Response to WSCC Strategic Planning Consultation Comments dated 6 September 2012

Proposed housing development at

**Roundstone Lane, Angmering
Arun Planning Application A/82/12**

23 November 2012

**Appendix 11**

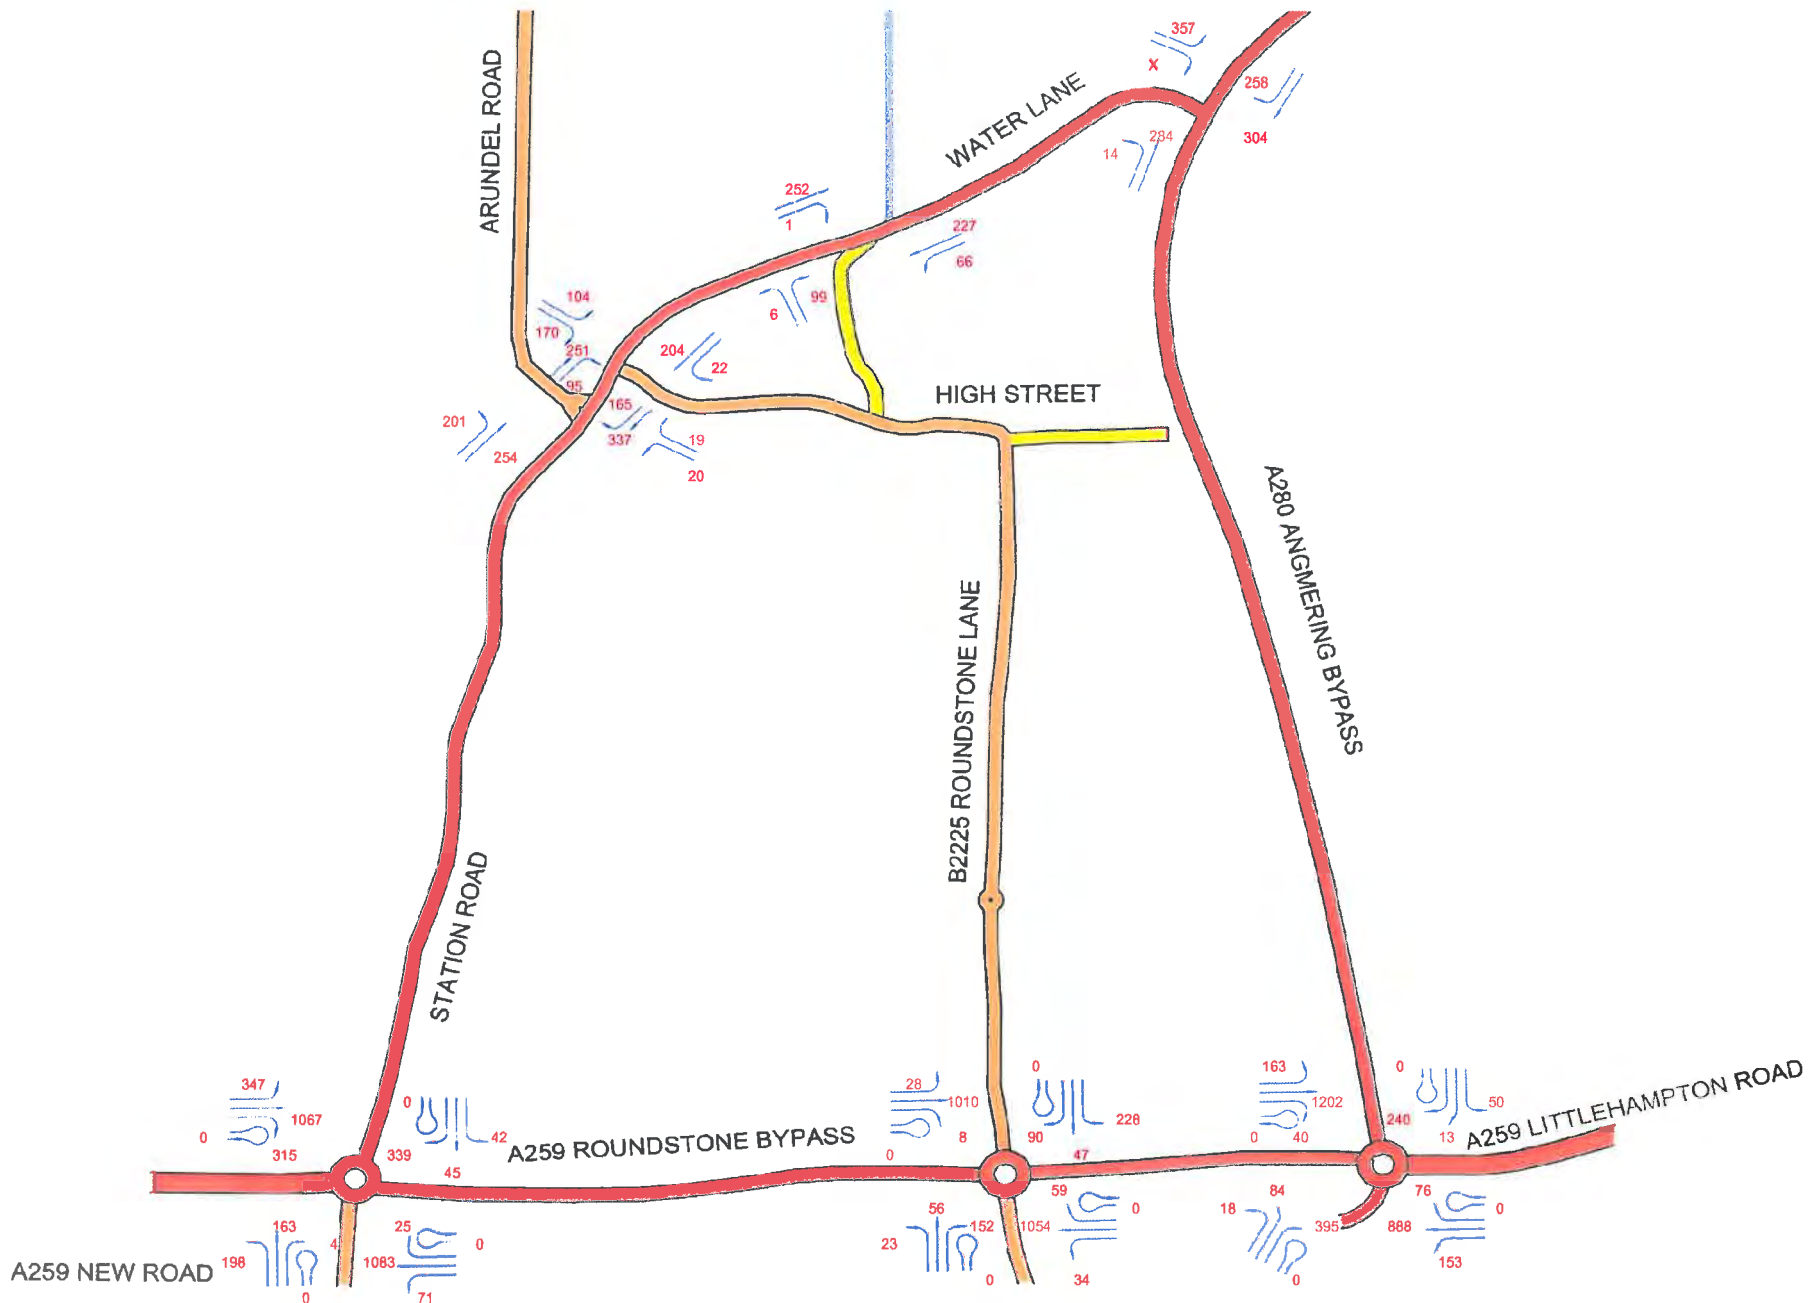
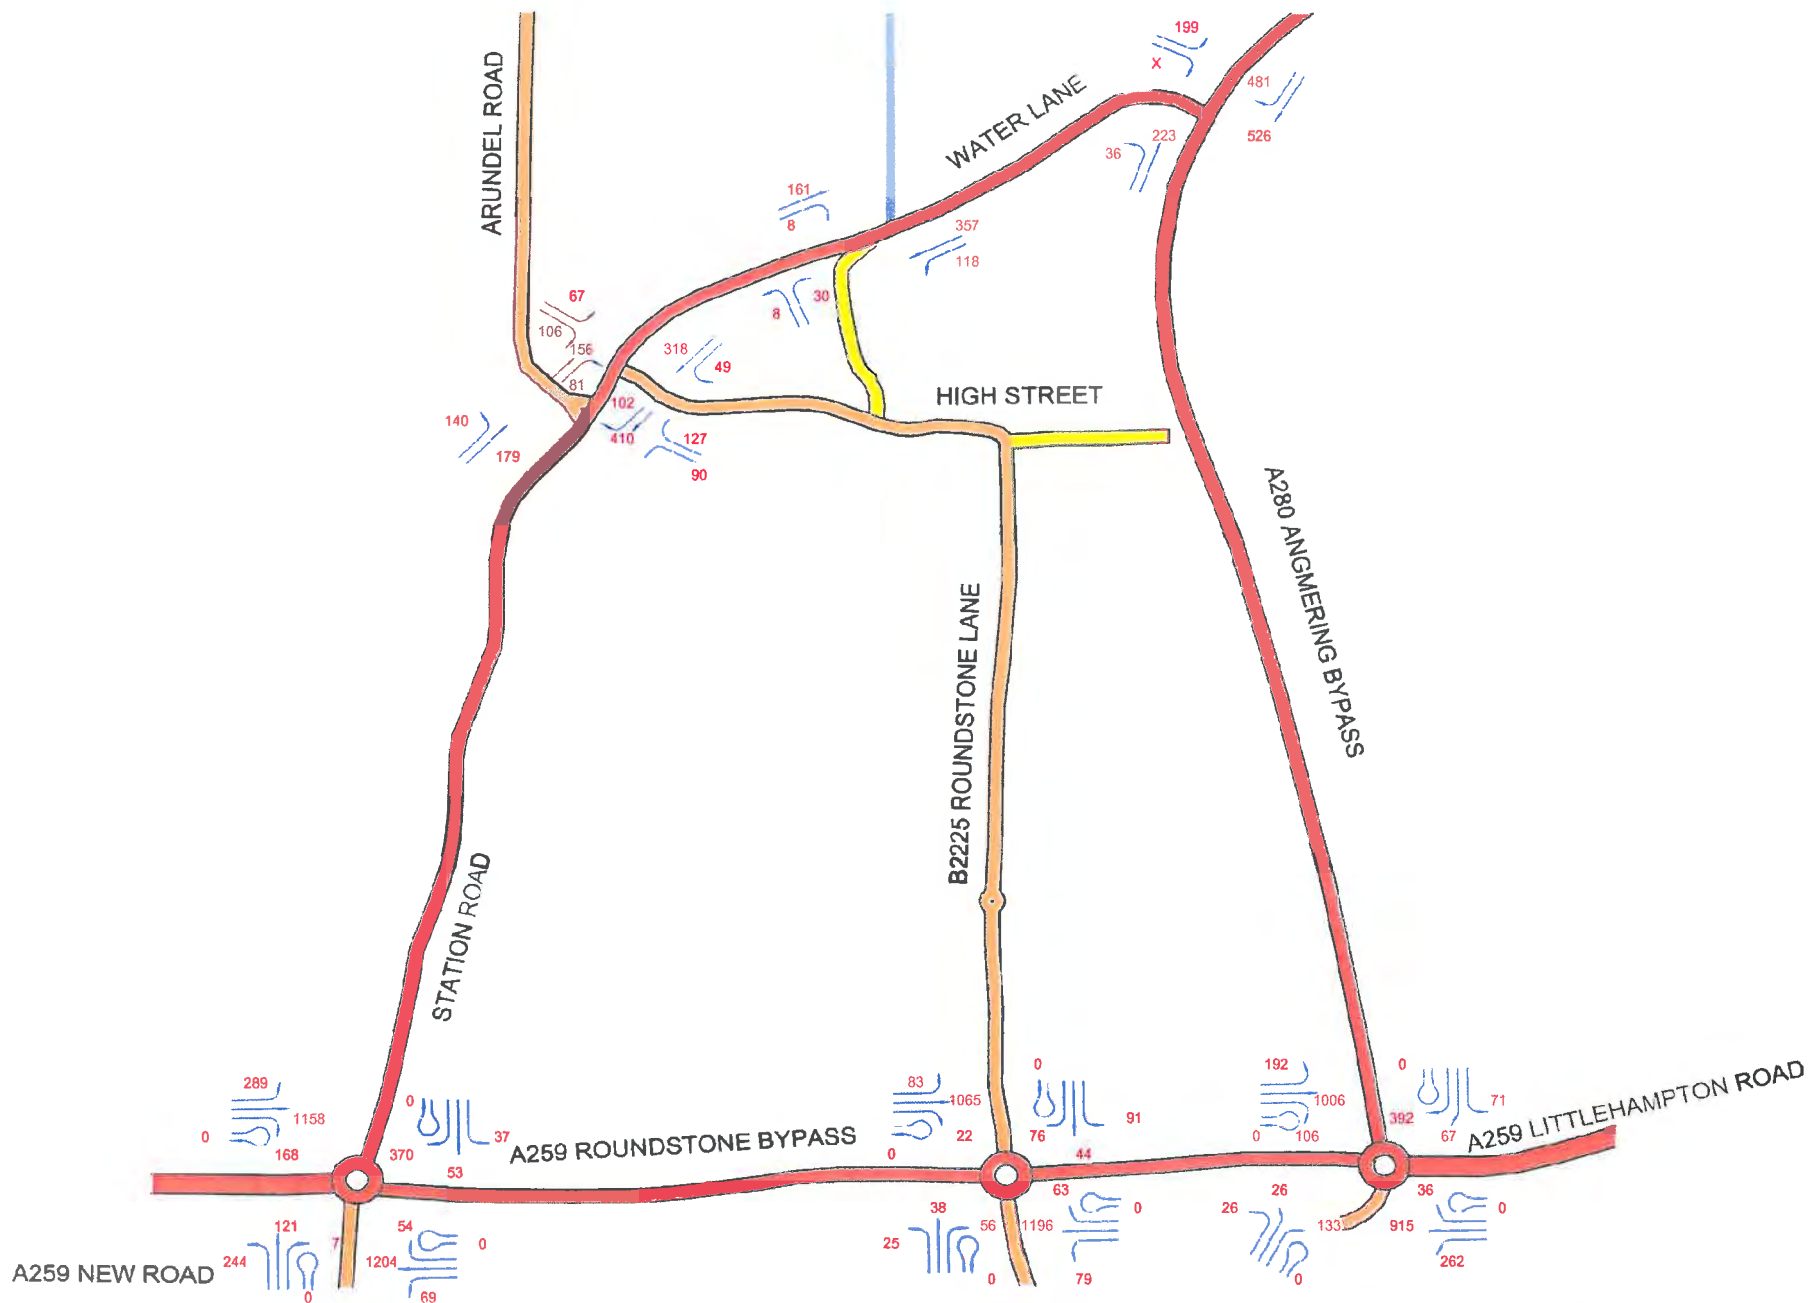
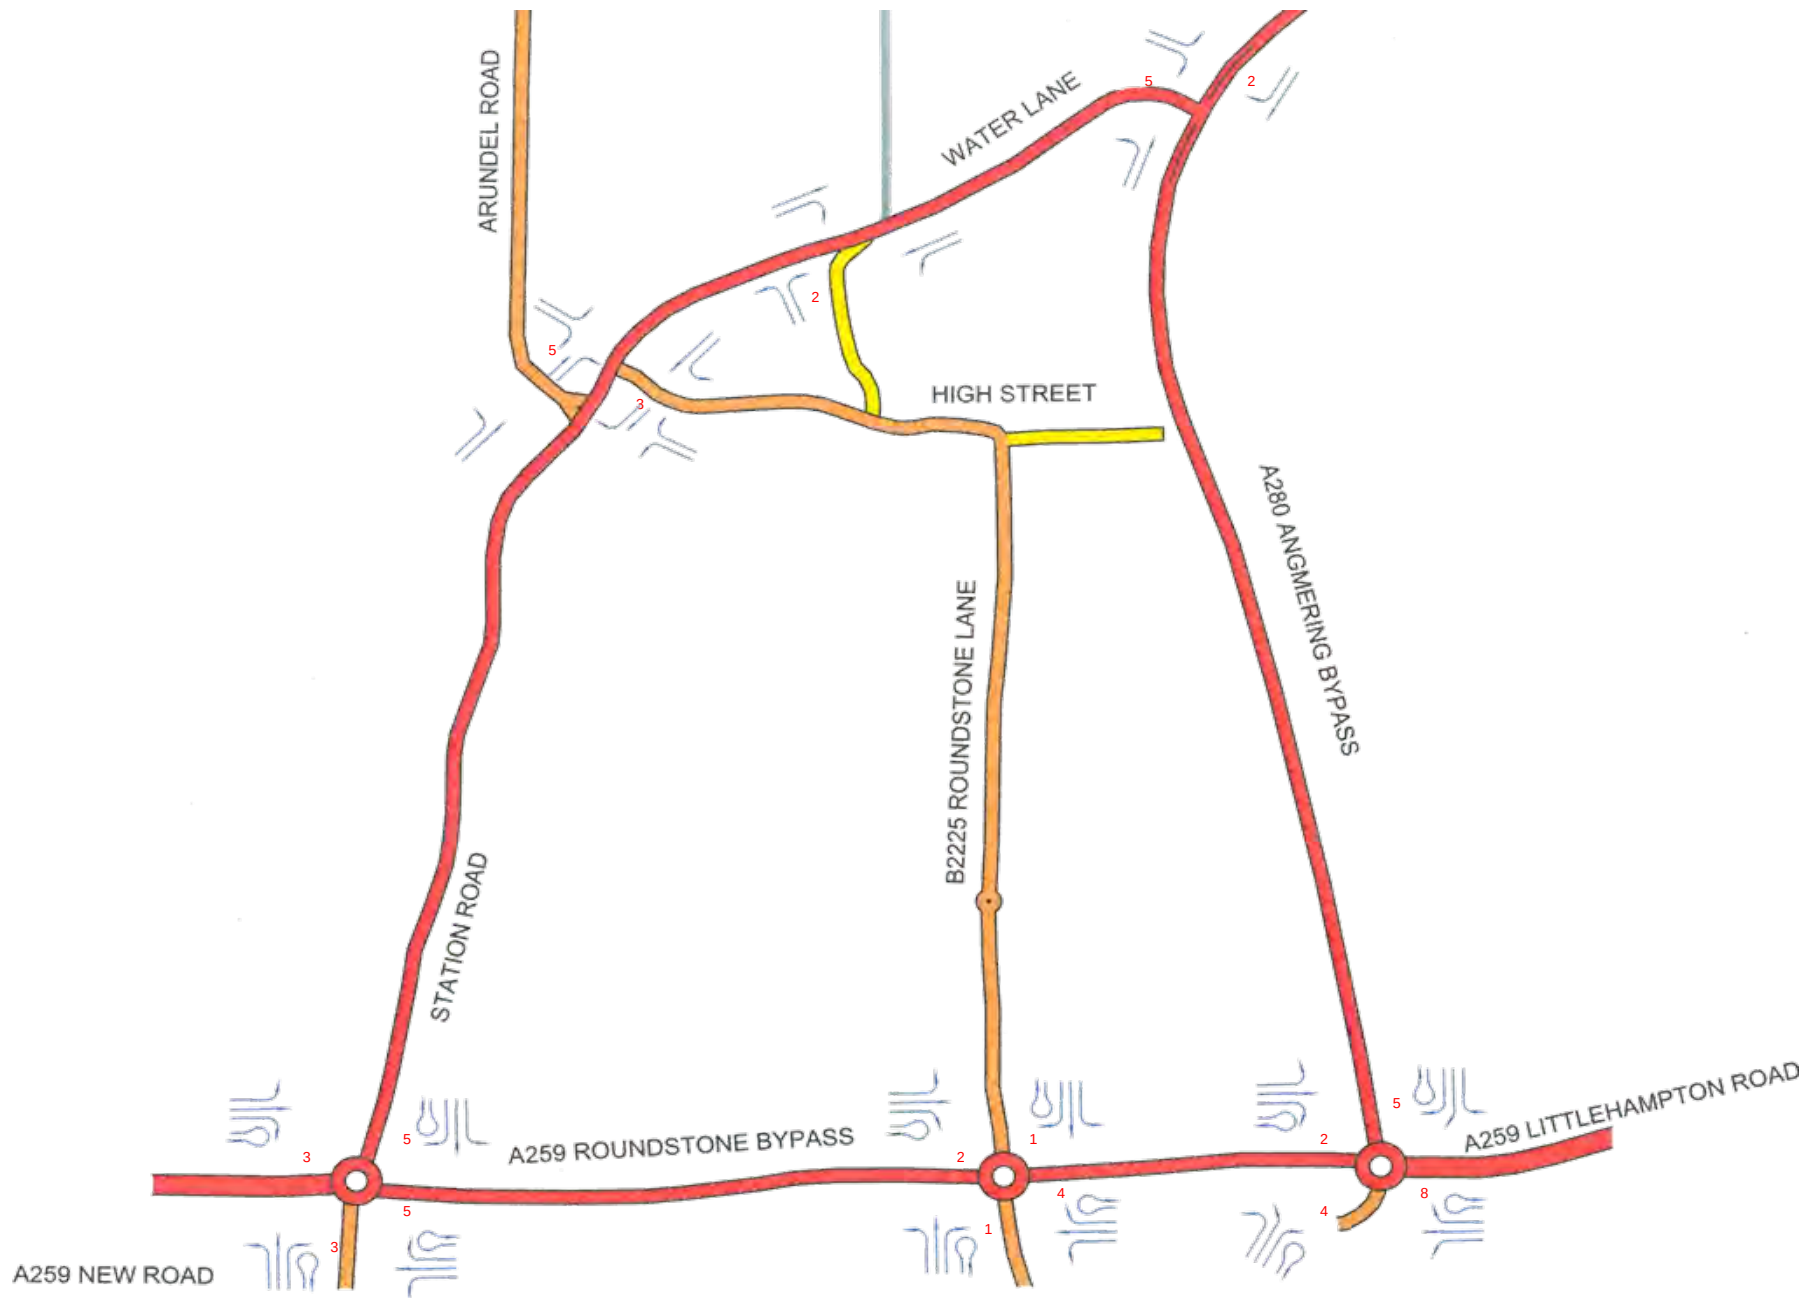
'Junction assessments: These do not appear to be consistent with observed traffic conditions on the A259 or at Water Lane/A283. The queue lengths in Appendix 11 appear to be lower than actual observed queue lengths during the morning and evening peak hours. Further detail should be provided on the junction assessments relating to the A259 to explain the relationship between observed congestion and the technical junction assessments.'

Queue length data taken during the traffic survey together with a summary in table and also schematic format is attached in Appendix 1 at the rear of this note.

The observed lengths in vehicles were noted every five minutes by the survey company. The summary queue lengths compiled by us from this data are mean average PCUs to match the definition of queue in TRL's ARCADY method. Capacity models are based on geometrical measurements taken from Ordnance Survey and aerial photograph. Percentage arm capacity adjustments have been undertaken where necessary such that the output from the ARCADY base model shows similar results.
